RE: Godzilla Short Plat (SP-11-00014)

The Kittitas County Community Development Services Department has determined that the Godzilla Short Plat (SP-11-00014) is a complete application and hereby grants *conditional preliminary approval* subject to the following conditions:

TO: Dan Valoff, Community Development Services
FROM: Christina Wollman, Planner II *CW*
DATE: January 17, 2012
SUBJECT: Godzilla Short Plat SP-11-00014

SHEET 1 OF 3

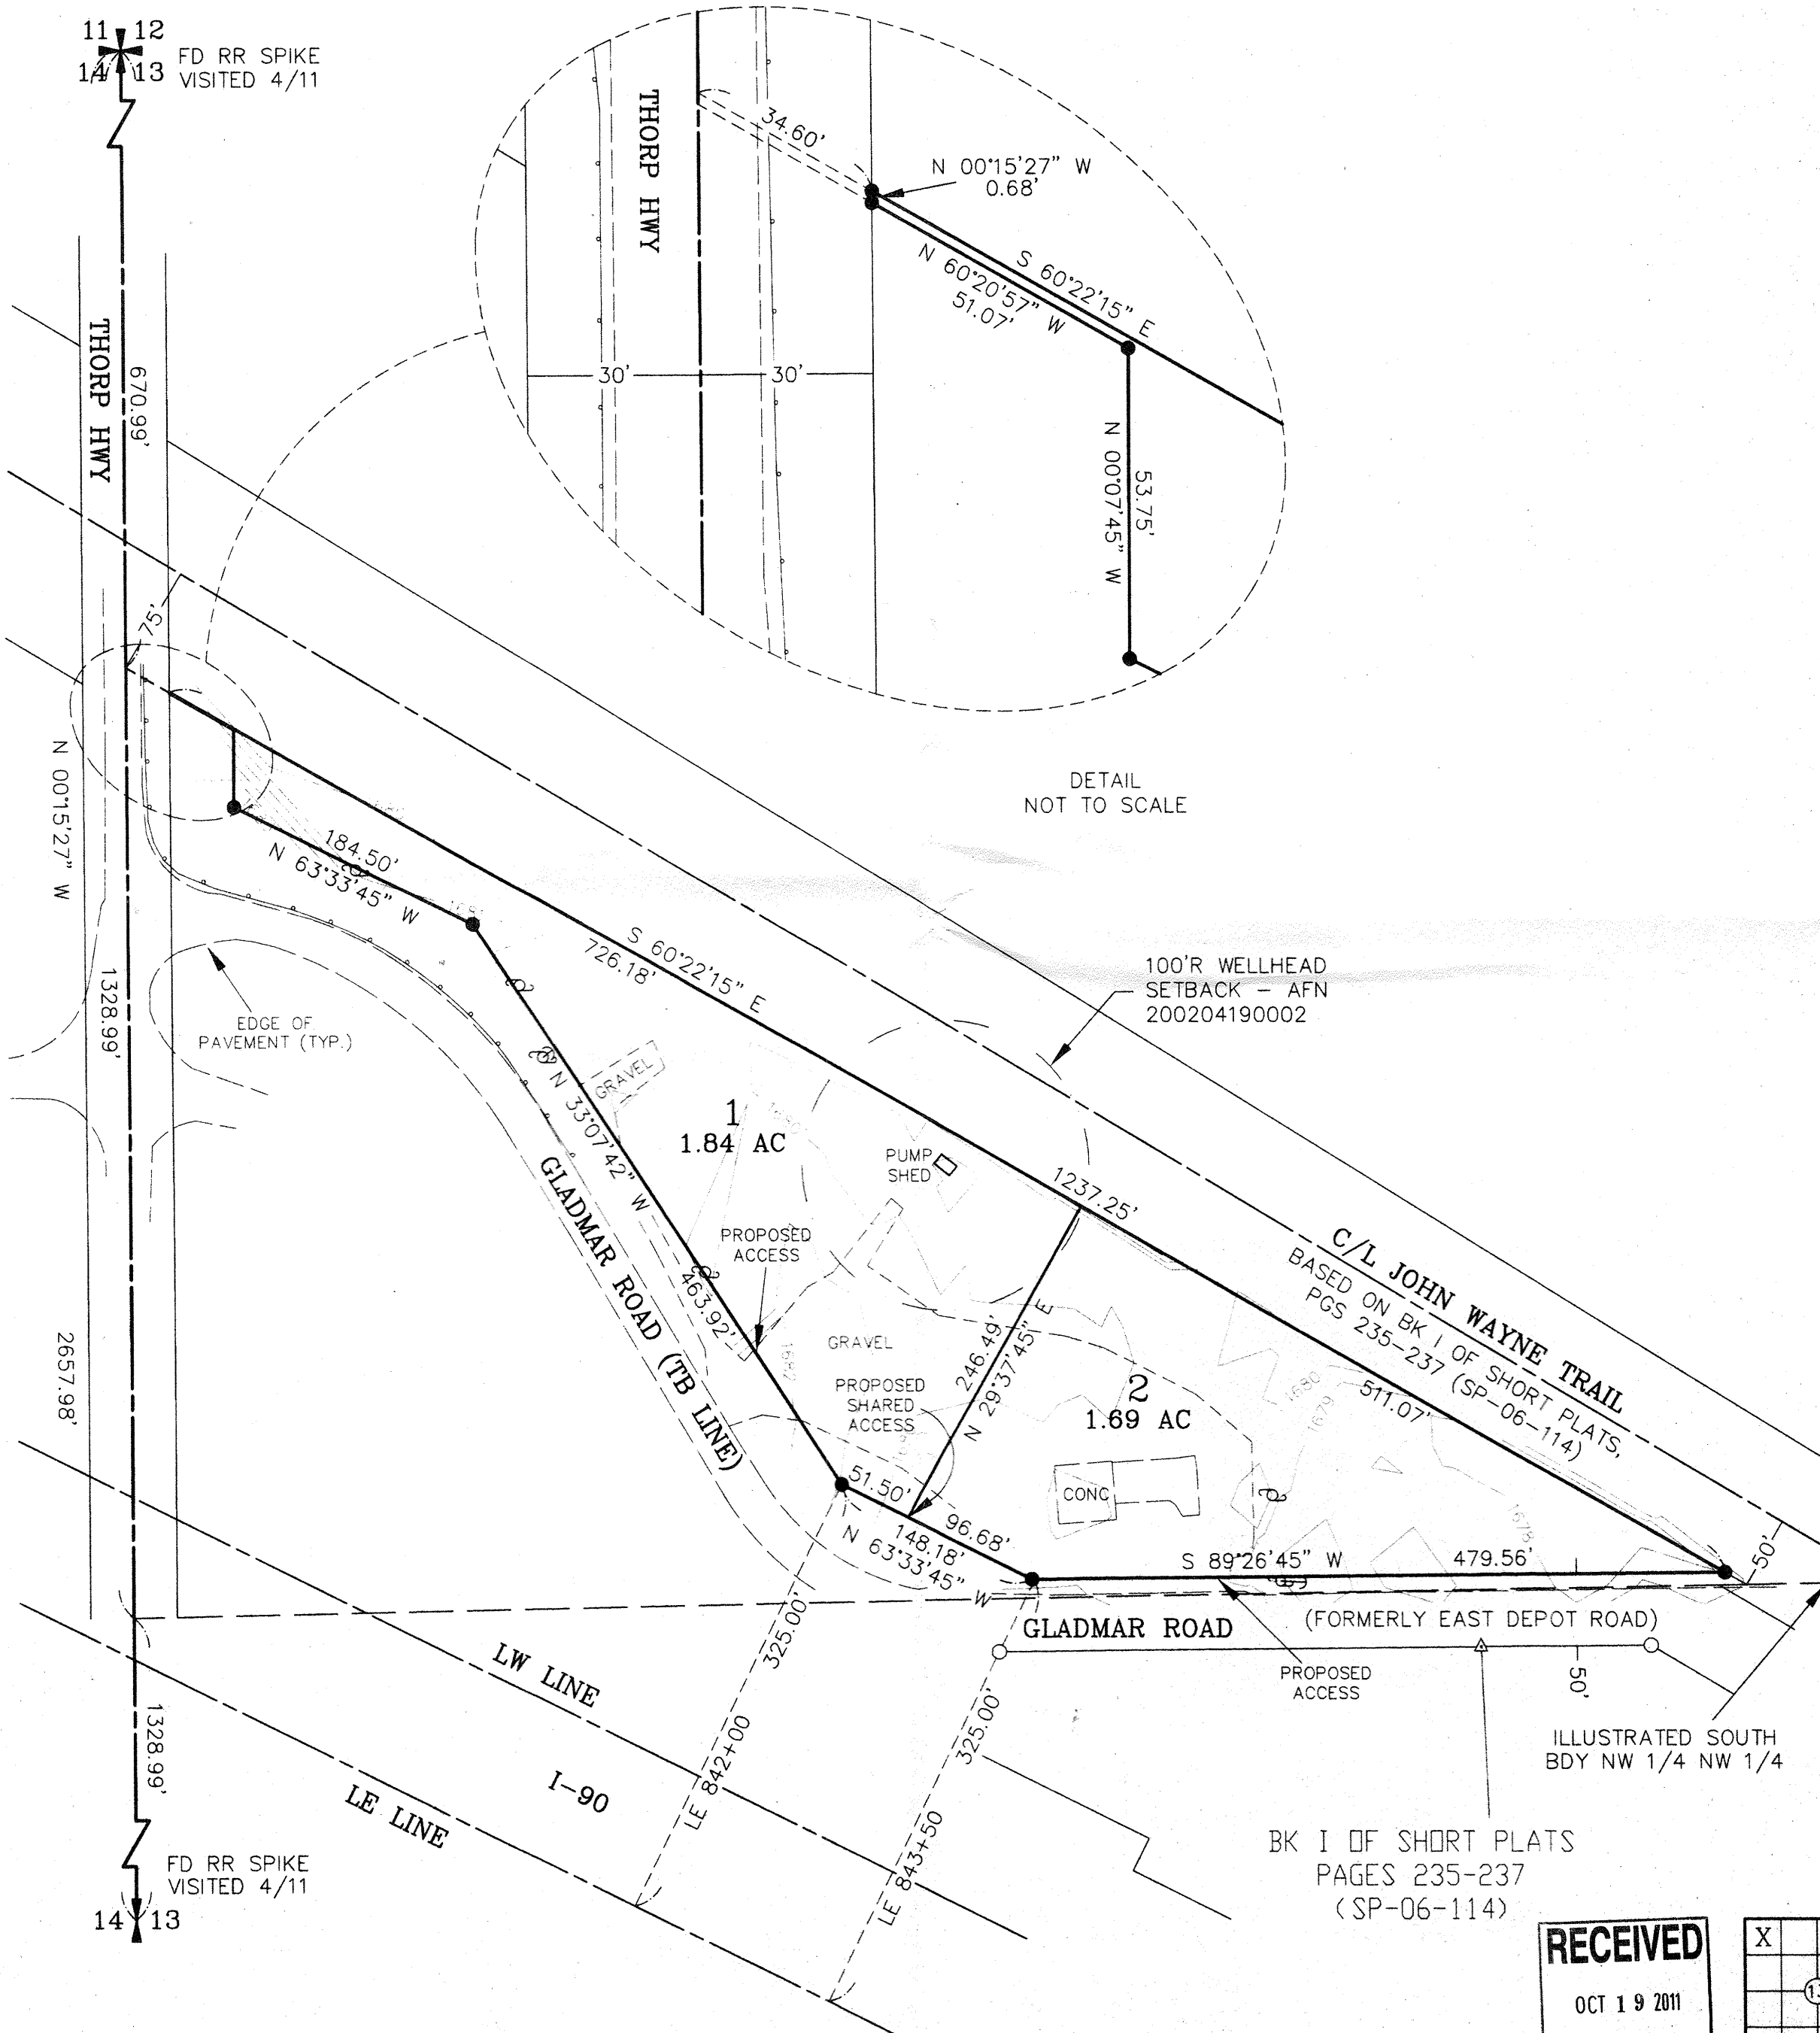
1. Both sheets of the final mylars shall reflect short plat number SP-11-00014 and an accurate legal description shall be shown on the face of the final plat.

6. A statement regarding the contemplated sewage disposal, water supply, and drainage improvements for the proposed subdivision shall be reflected on the final mylars.

1. Access: Each parcel is allowed one access to Gladmar Road, provided the access location meets sight distance requirements. An additional shared access may be allowed if the location meets sight distance requirements and is allowed by the County Engineer. Currently, the proposed shared access location does not meet these requirements. Any existing accesses will need to be removed prior to use of any new access.
